# KITITAS COUNTY

### MEMORANDUM

**TO:** All Staff  
**FROM:** Public Works Plan Review Team  
**DATE:** November 21, 2025- Survey Update  
**SUBJECT:** BL-25-00018 Helveston

RECORD OF SURVEY
LOT 1, BLOCK G, SUNLIGHT WATERS II
PART OF THE SOUTHEAST QUARTER OF SECTION 24,
TOWNSHIP 19 NORTH, RANGE 16 EAST, W.M.

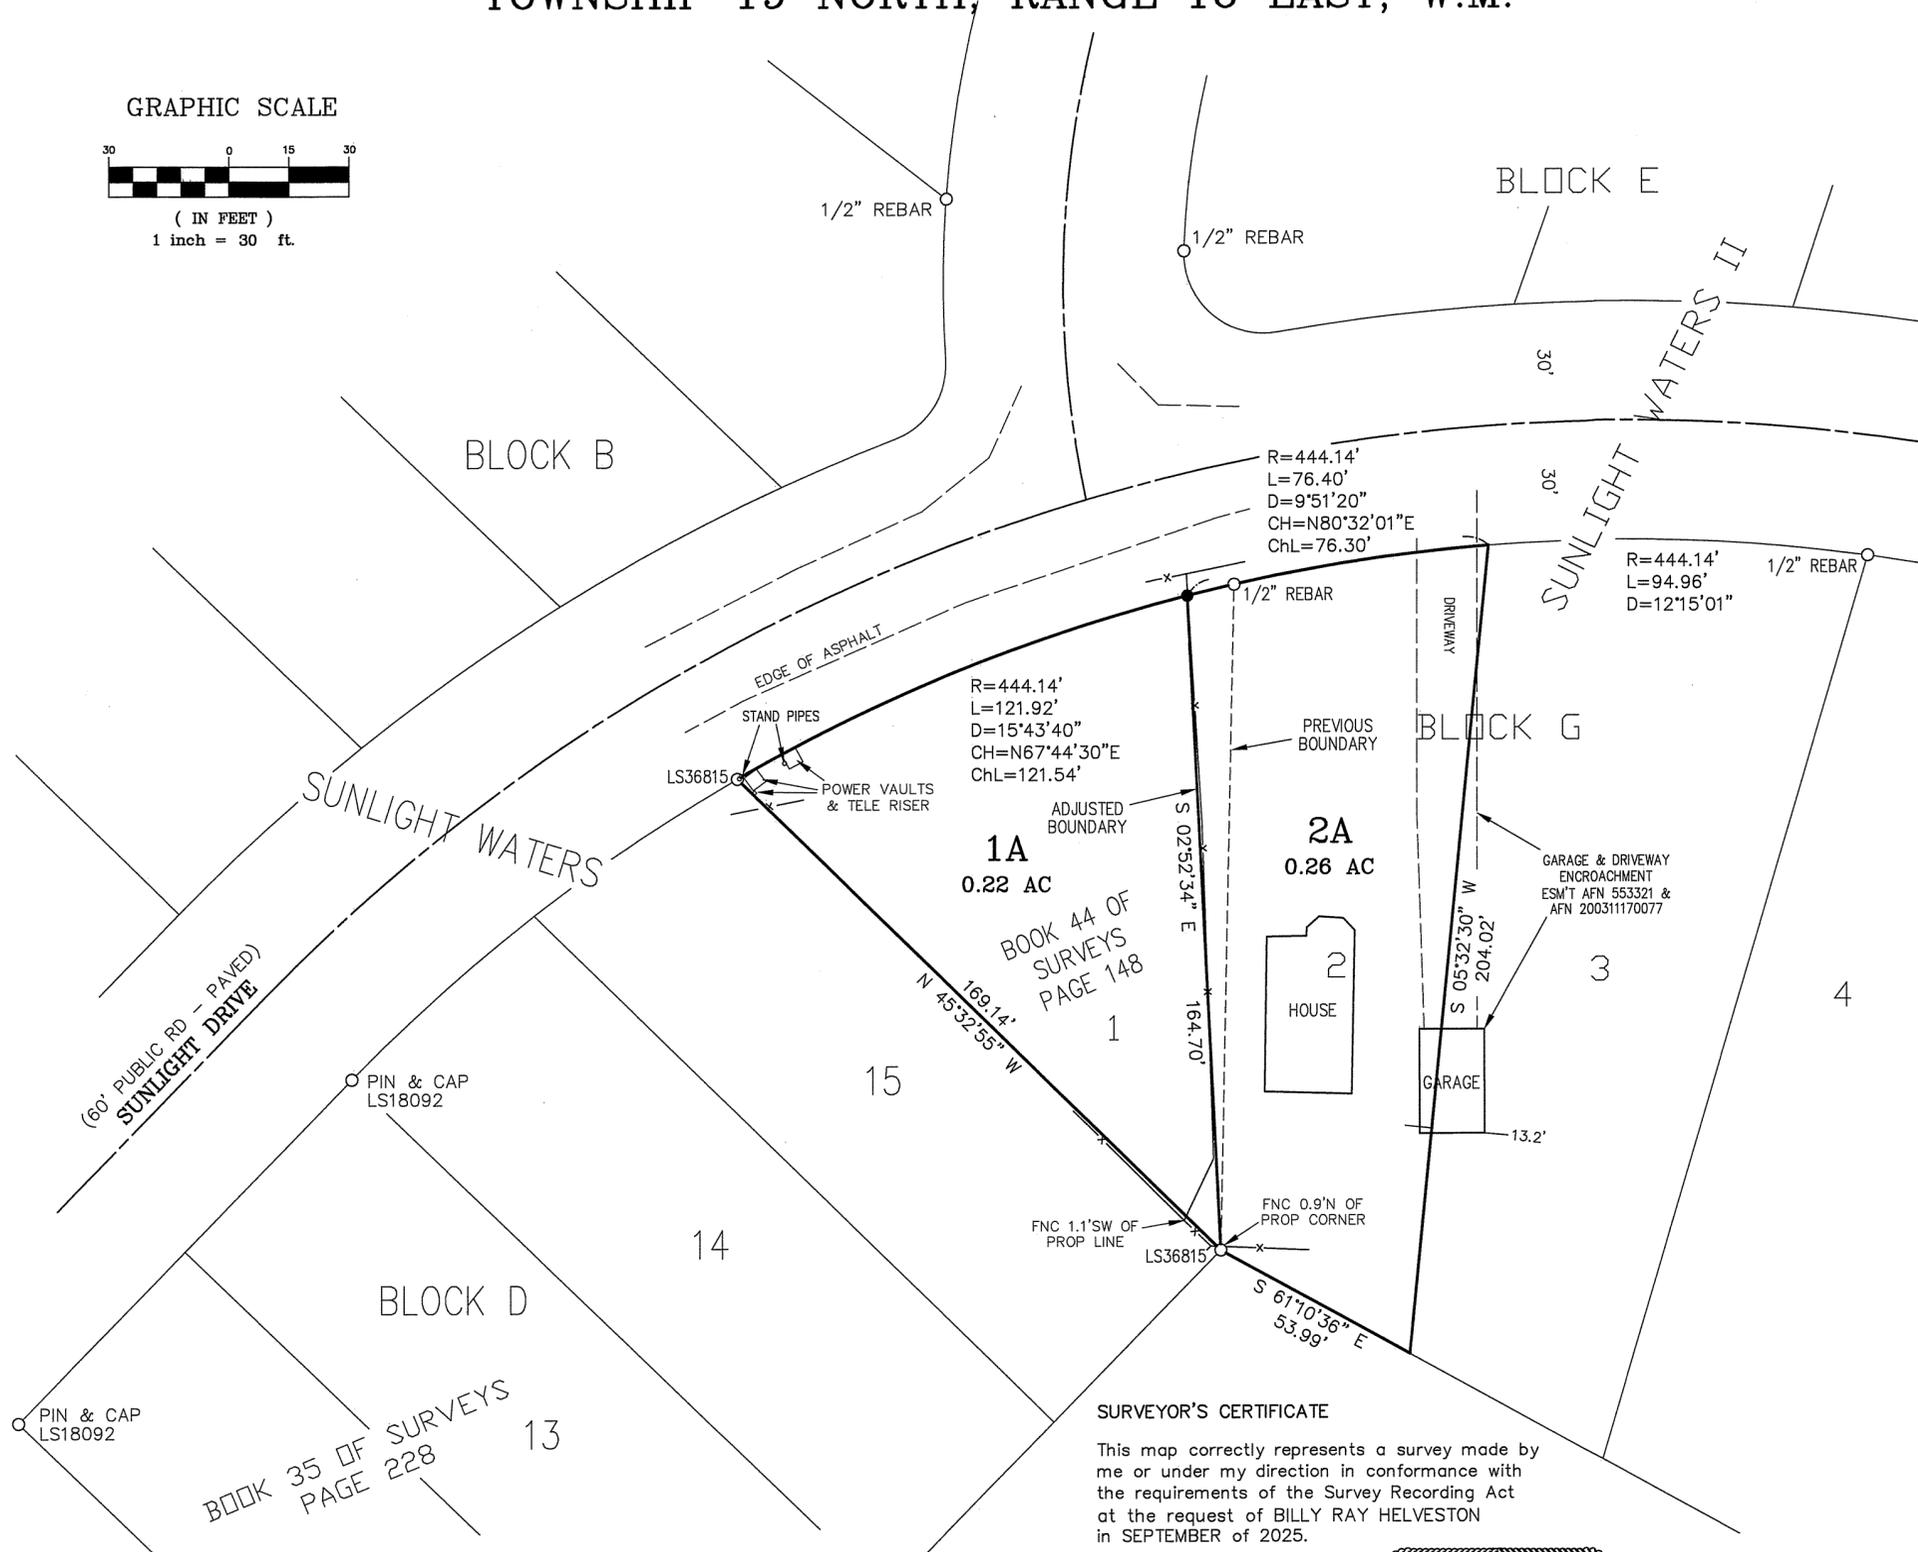
<b>SURVEY</b>	<p>Waiting for final application/Record of Survey before making comments.</p> <p>UPDATE 11/21/2025</p> <ol style="list-style-type: none"> <li>1. If any of the found property corners shown were utilized for survey control, bearings and distances to these corners should be shown on the face of the map.</li> <li>2. Please clarify the diagonal line located near the s' most corner of Lot 1A.</li> </ol> <p>OF NOTE  Including a label for Ridge Loop Road would be a benefit to the public record.  (JT)</p>
<b>TRANSPORTATION CONCURRENCY</b>	No Comments.(RC)
<b>FLOOD</b>	No comments. (SC)
